Rezoning Transportation Analysis
Petition Number: Insert Zoning Petition #2020-181
General Location Identifier: 11122105

Revision Log:

Date	Description
01-21-21	First Review (WB)
02-15-21	Second Review (WB)
04-23-21	Third Review (WB)
05-27-21	Fourth Review (WB)
09-28-21	Fifth Review (BKB)
10-13-21	Sixth Review (BKB)
10-26-21	Seventh Review (WB)

REZONING PLAN

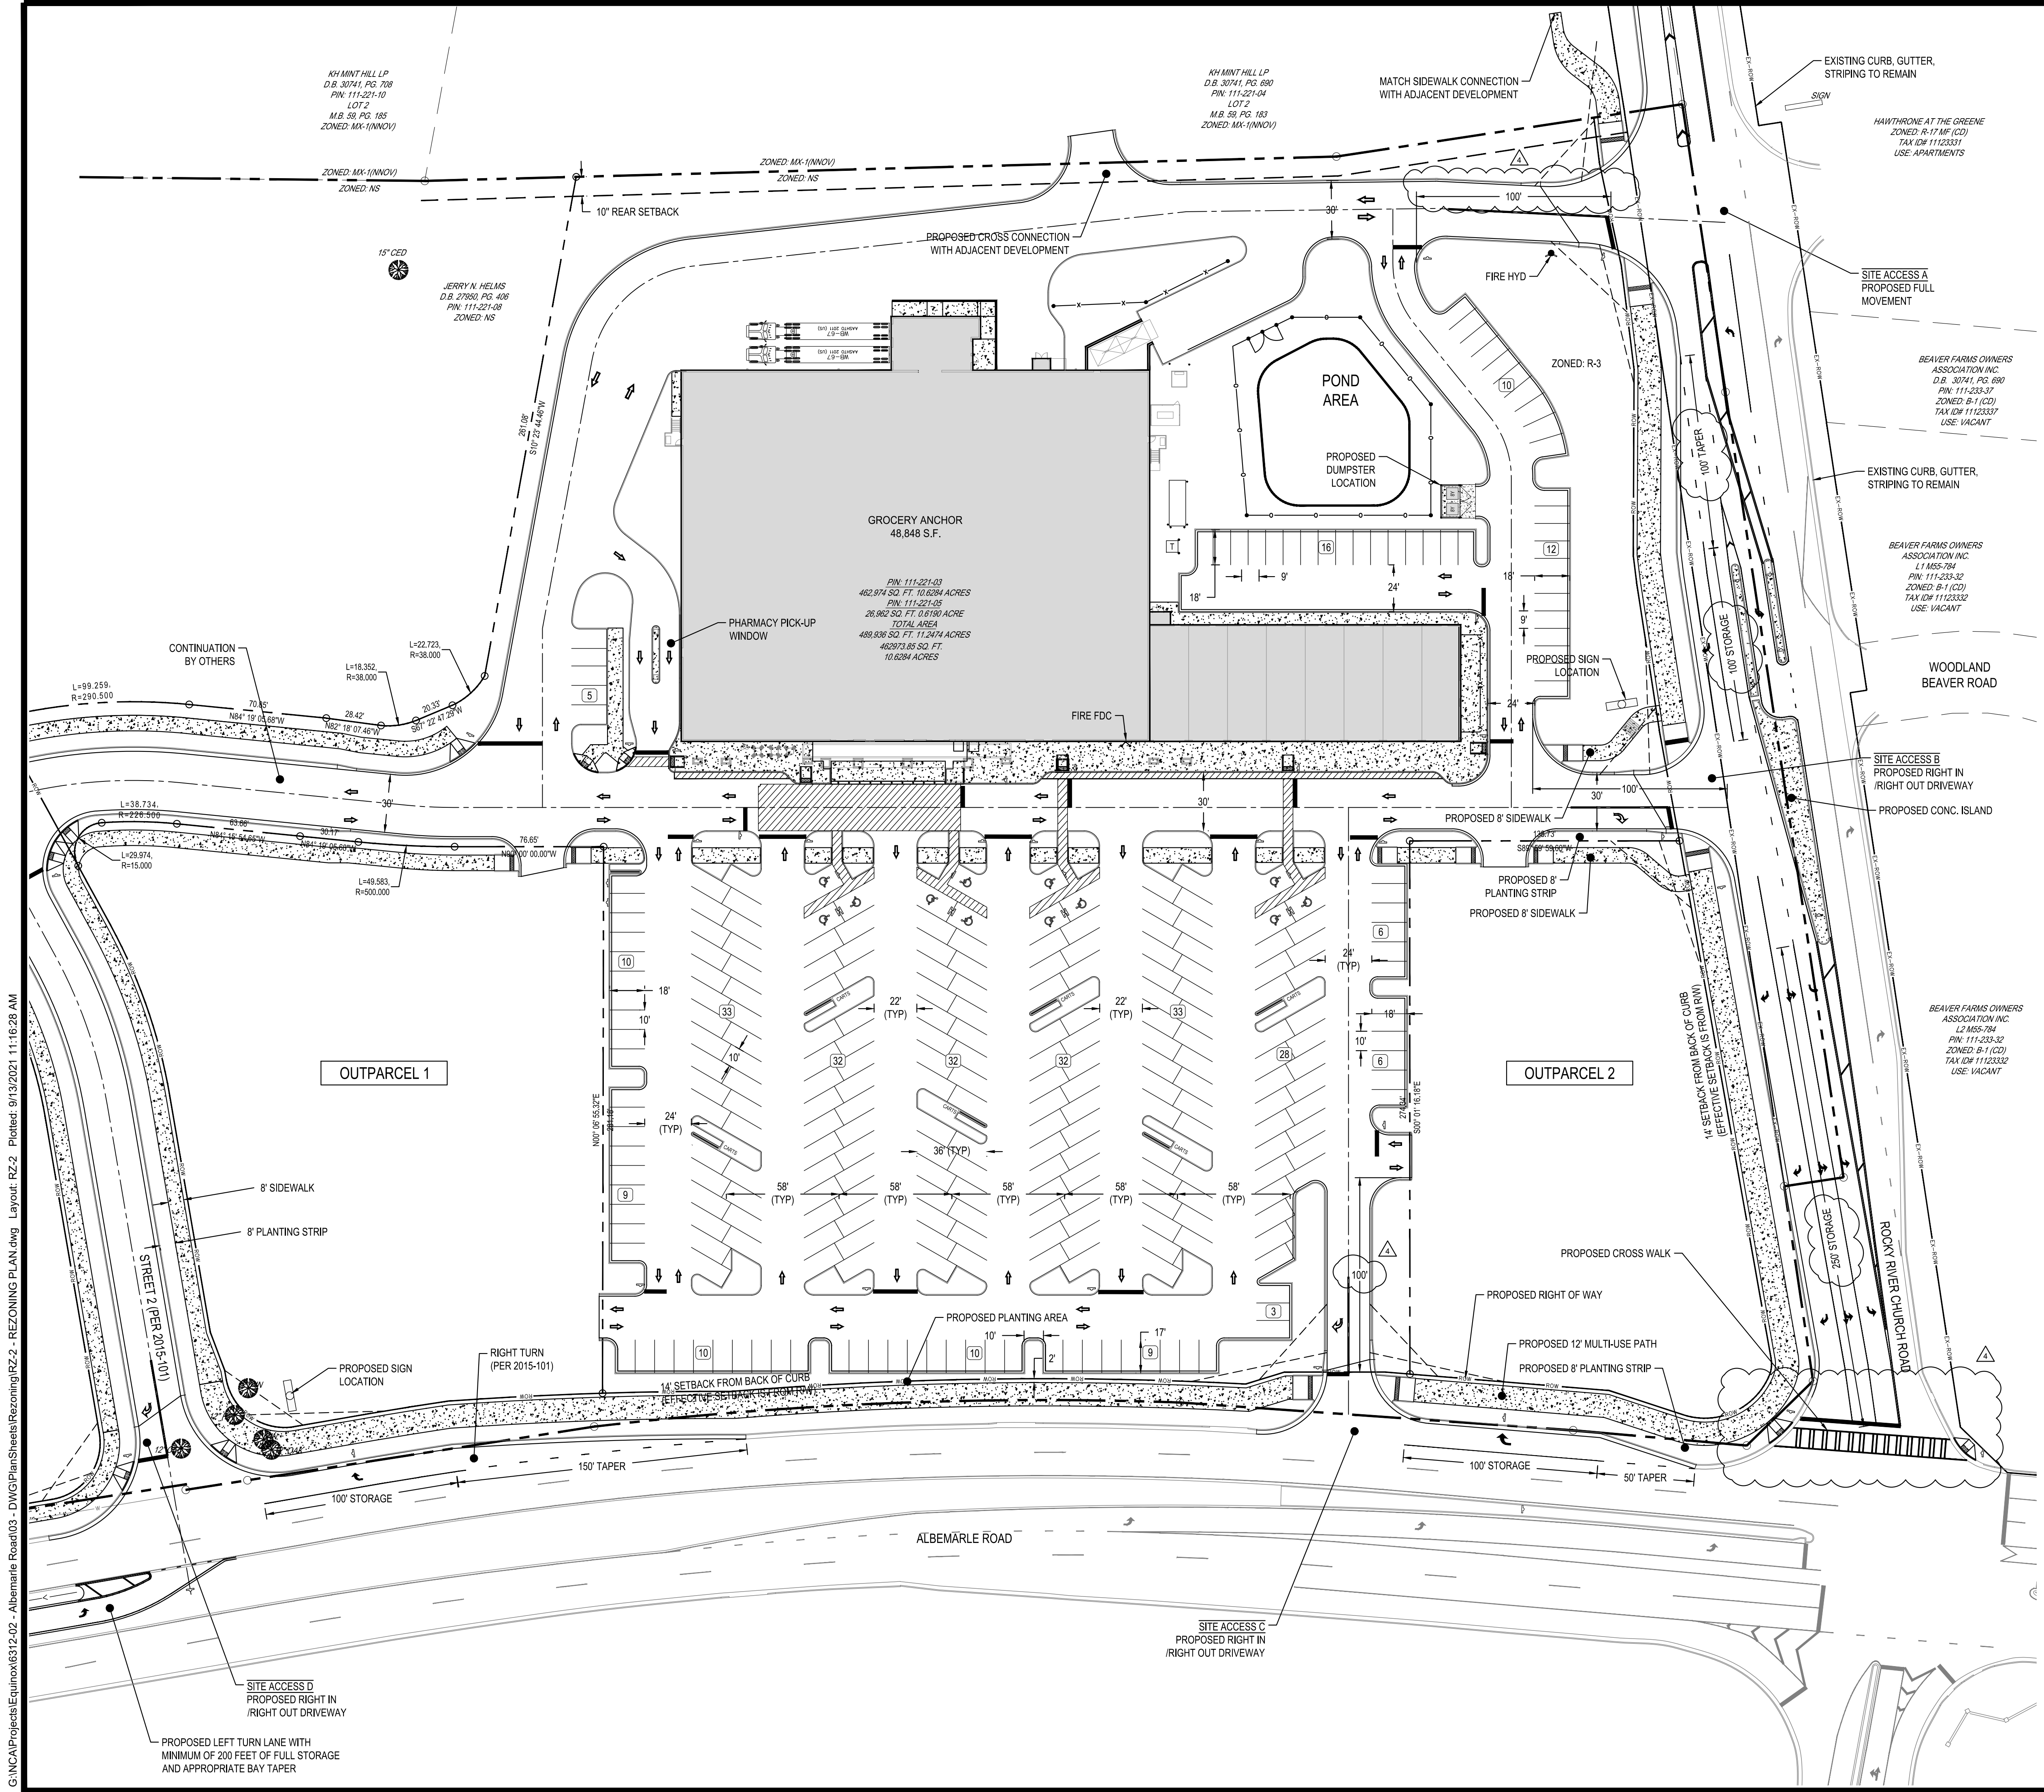
1. ~~**Curblines:** The proposed zoning district has a setback measured from back of the existing or proposed future curblines.~~
 - a. ~~**Albemarle Road:** The site plan reflects the future location of curb and gutter.~~

~~Label and dimension the curb and gutter from the centerline for each road on the site plan.~~

- a. ~~R/W line should be straight along the Albemarle Road frontage. Remove the taper.~~
- b. ~~Revise site plan and conditional notes to reserve an additional 12' right of way along the frontage of Rocky River Church Road to accommodate a future roadway widening.~~

3. **New Comment Revised (based on site plan submitted on 02/09/21).**
 Revise site plan to commit to providing intersection improvements to include the recommended lane configuration at the Albemarle Rd at Rocky River Church Road per Rezoning Petition 2020-101. Improvements shall include the continuation of the curb and gutter around the curb return. **RESOLVED 4-19-2021**

4. **Comment Revised (based on Comment review meeting held on 2/5/2021).**
 Revise site plan to label and dimension the dedicated the Public Street right of way 2 per Rezoning Petition 2020-101. Street 3 will be constructed as a private street; however, the petitioner shall provide pedestrian connectivity on the south side of the proposed street. The site plan shall label and dimension an 8-foot planting strip and an 8-foot sidewalk on Street 2 and on the south side of Street 3.

5. ~~Site plan and conditional note(s) revisions are needed to commit to constructing a 12' multi-use path with an 8' planting strip along the site's frontage in accordance with the Charlotte BIKES and Charlotte WALKS Policies. The petitioner should coordinate with the developer of Approved Rezoning Petition 2020-007 to ensure that intersection improvements provide continuity between the multi-use path and planting strip on both sides of Rocky River Church Road. The site plan shall label and dimension both items from the back of curb and gutter and road centerline.~~

6. ~~Revise site plan and conditional note(s) to commit to constructing a concrete median with a left-over on Rocky Rover Road to maintain left turns into Woodland Beaver Rd and prevent left turns into the site's southmost access into the site.~~

7. ~~Site plan and conditional note(s) revisions are needed to commit to providing intersection improvements to accommodate pedestrian and bicycle crossings at the Albemarle Road and Rocky River Church Road Intersection. These improvements shall include accessible ramps, channelization islands and all associated infrastructure modifications needed to provide a safe route for both bicyclists and pedestrians and align with those improvements found and approved as part of RZP 2020-007.~~
